From: Nicola Moore
To: [REDACTED]
Subject: RE: Request for further information AW/312/20/PDH
Date: 10 November 2020 09:27:00
Attachments: image014.png

With reference to our application ref: AW/312/20/PDH for 33 Gossamer Lane, PO21 4BX, please find attached the requested block and location plan.

BLOCK PLAN
SCALE 1:500 @ A1

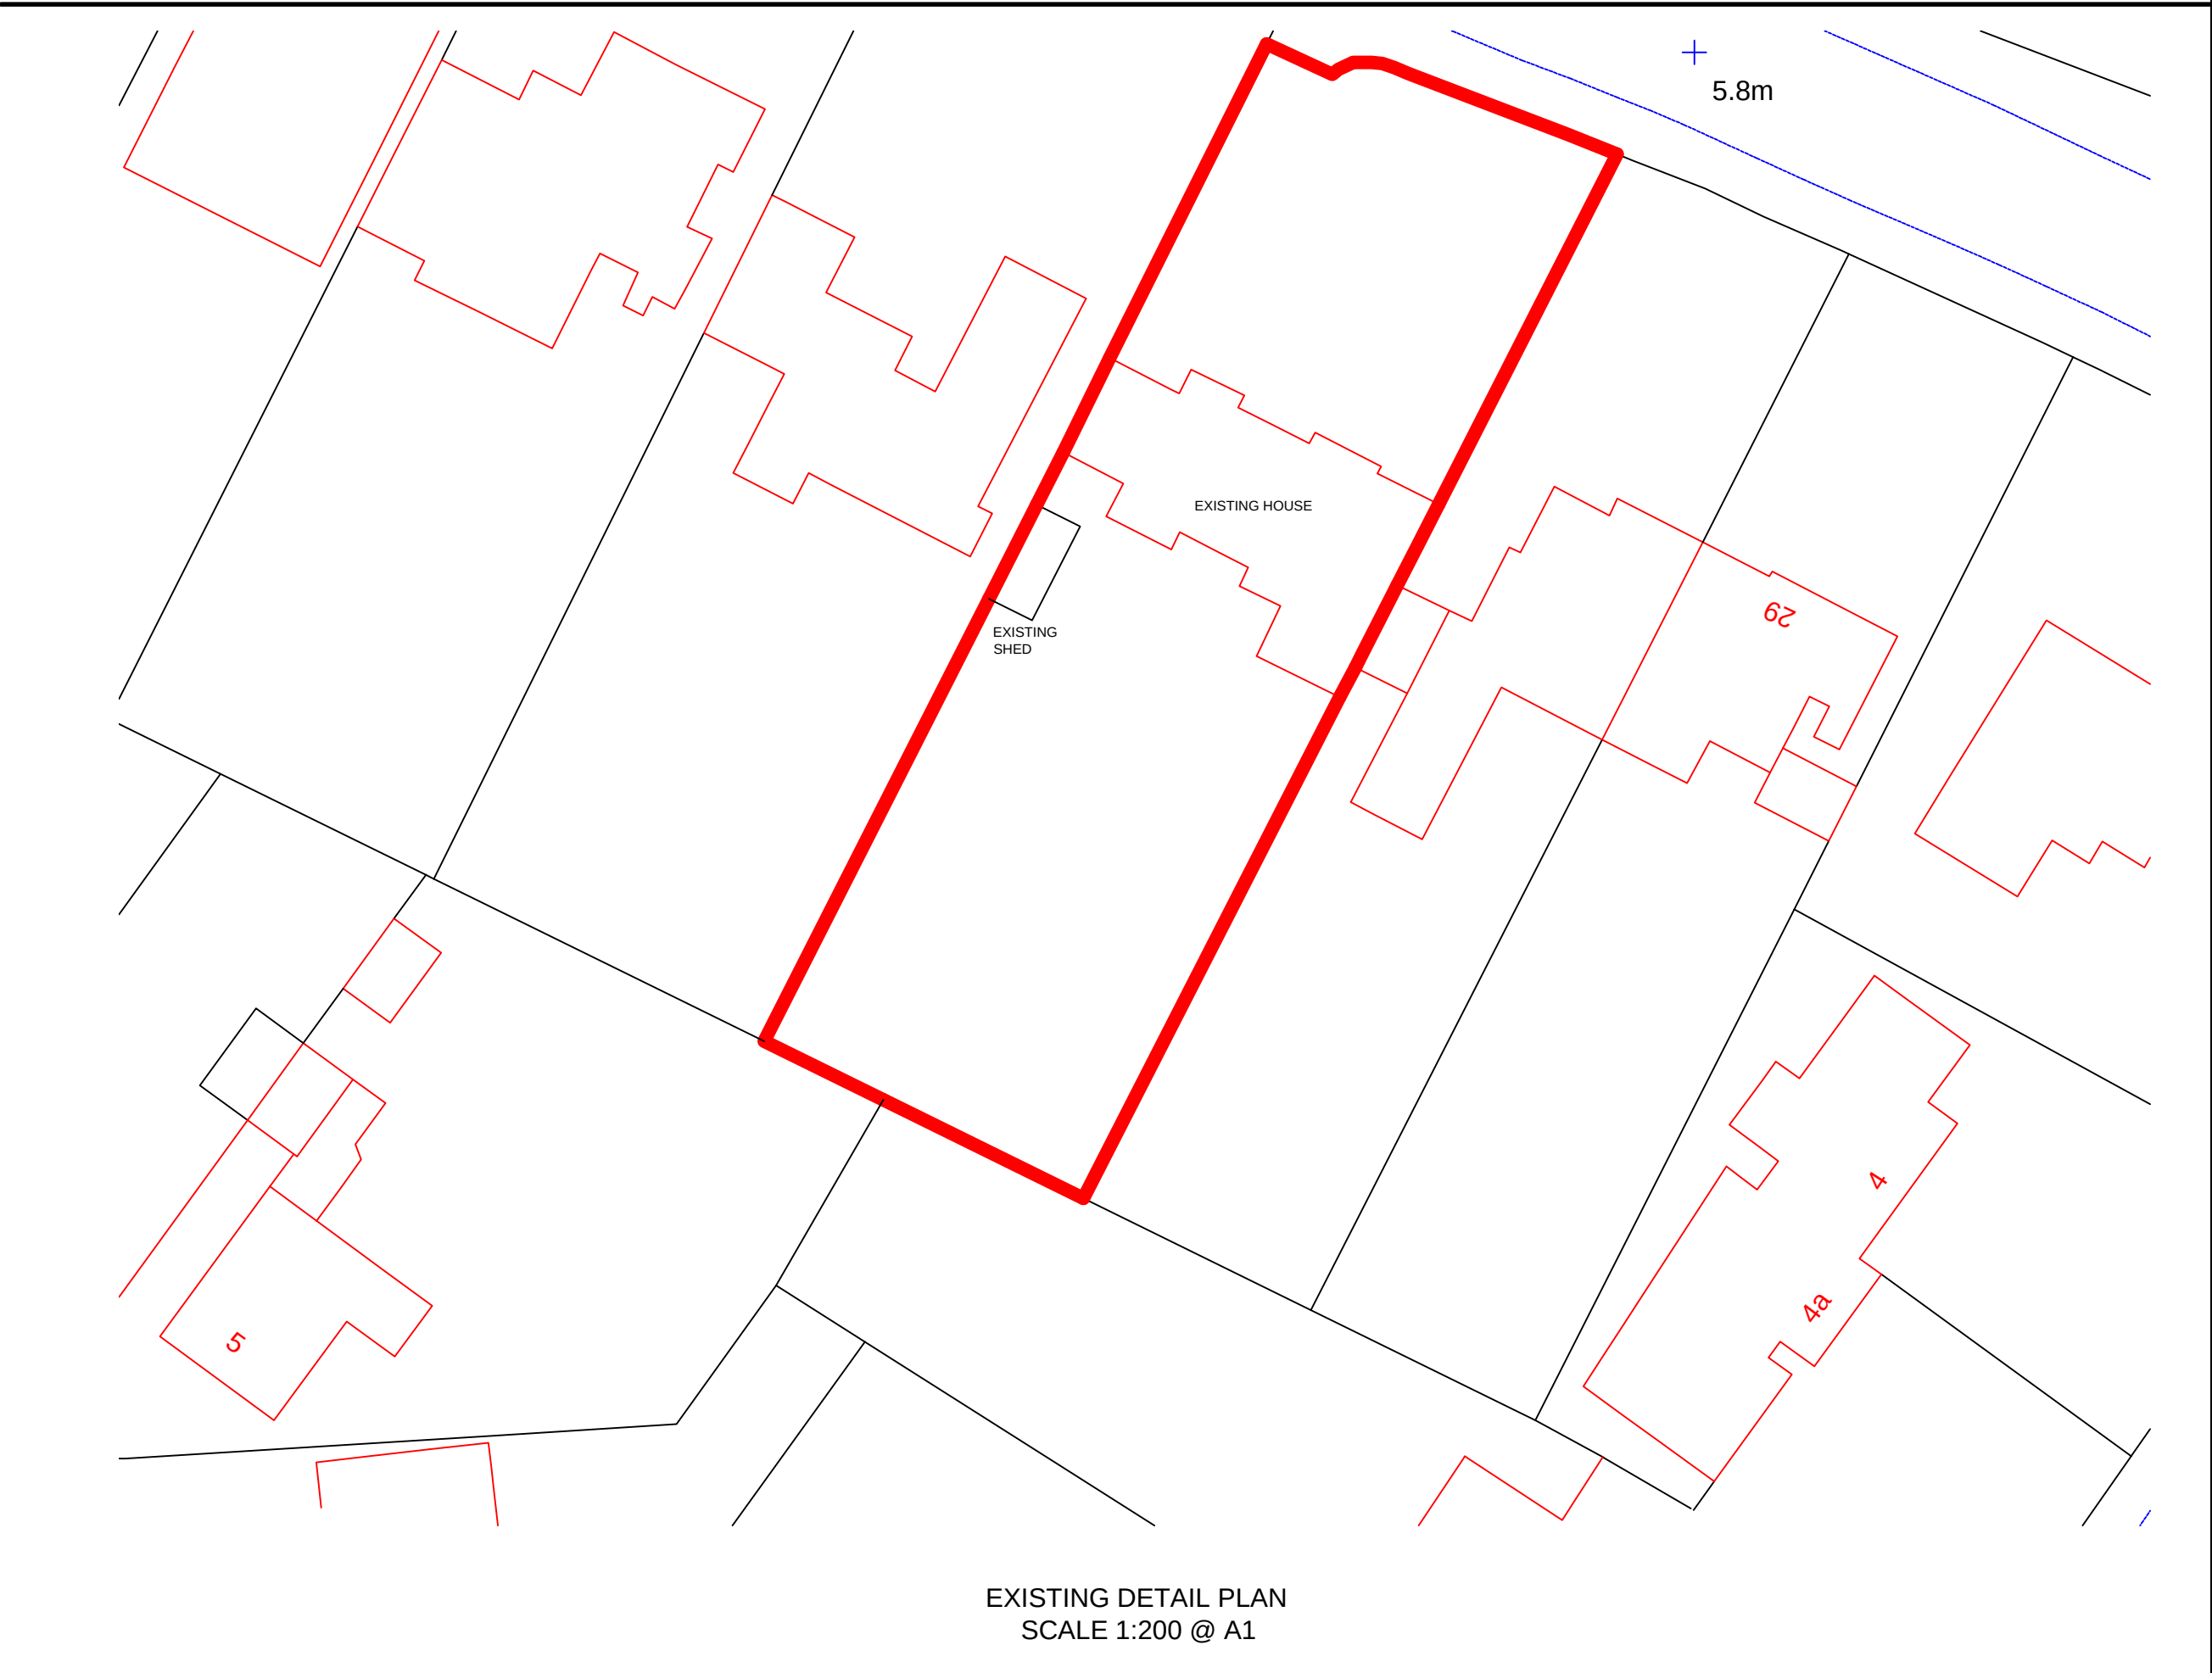
Thank you for the Location and Block Plan received today. The Block Plan should show the proposed development in relation to the site boundaries (this can be hatched, highlighted or colour) and the dimensions to the boundaries.

Please amend accordingly and resubmit.
